I hope you don't mind me emailing you direct but there does not seem to be the opportunity for public comment on the conditions discharge by Jones Homes as per the reference above.

1. Validation date on the website appears to be 14<sup>th</sup> February 2024 for a submission date on the application form of the 29<sup>th</sup> February 2024. Can this be explained?

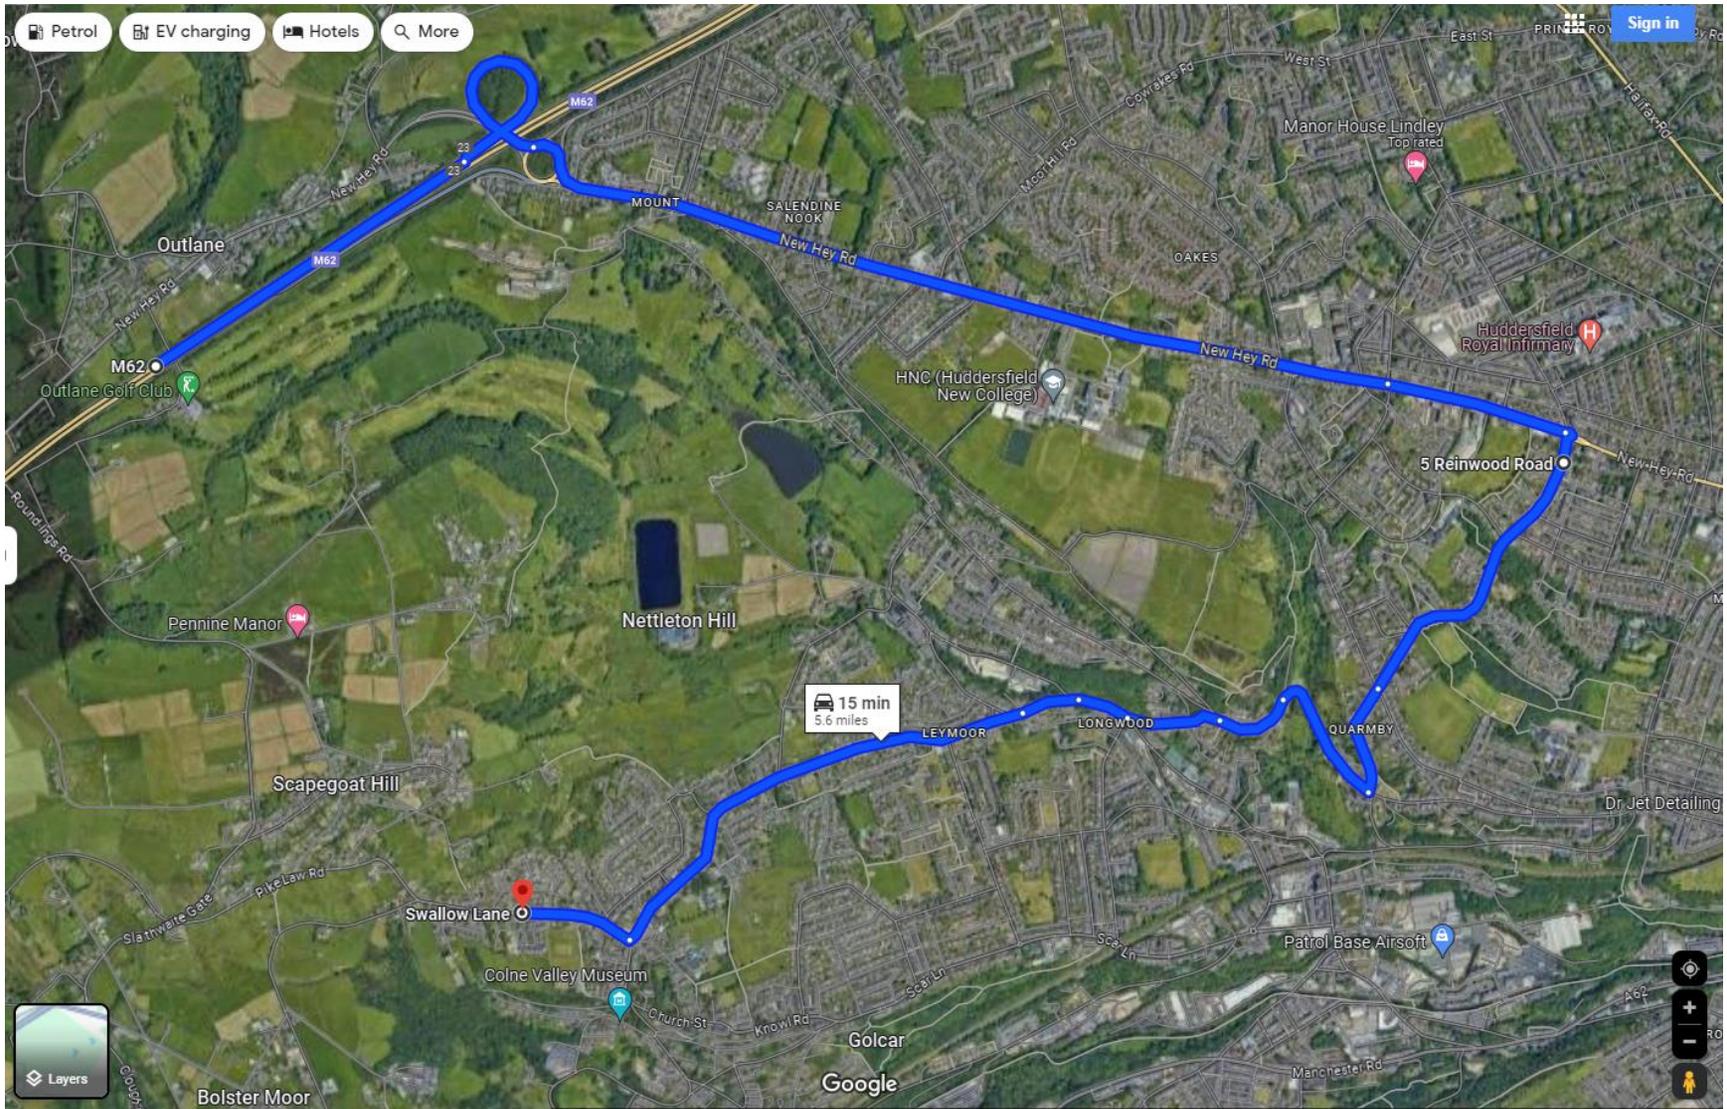
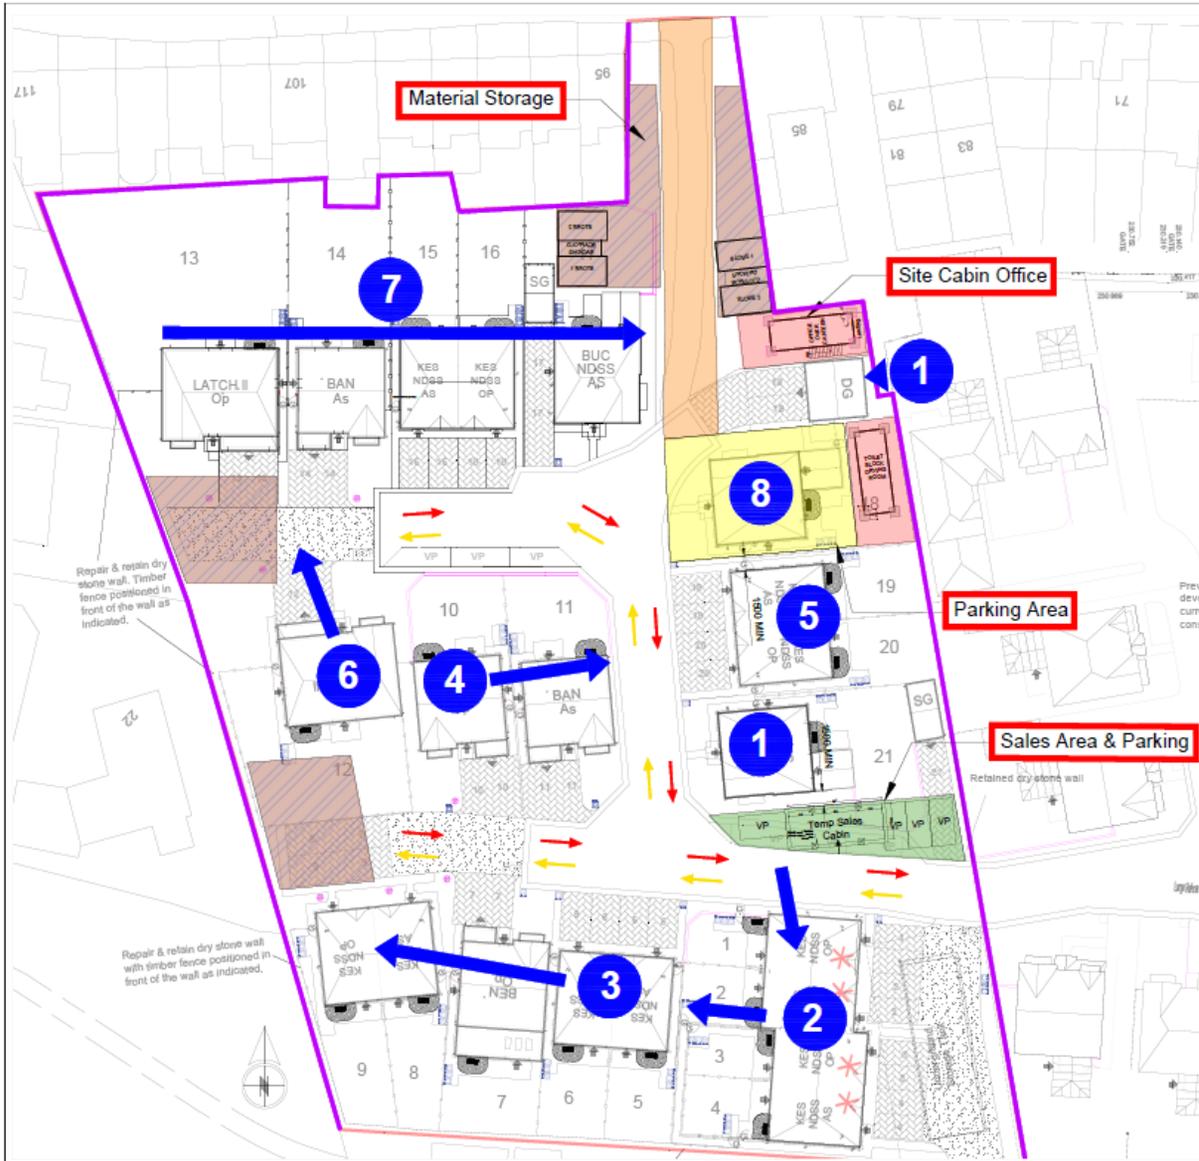
4. Appendix 1 – Traffic route is already being ignored during the initial phase of works with muck away wagons dropping into the village from scape, reversing into century view with no control or banksman from the highway
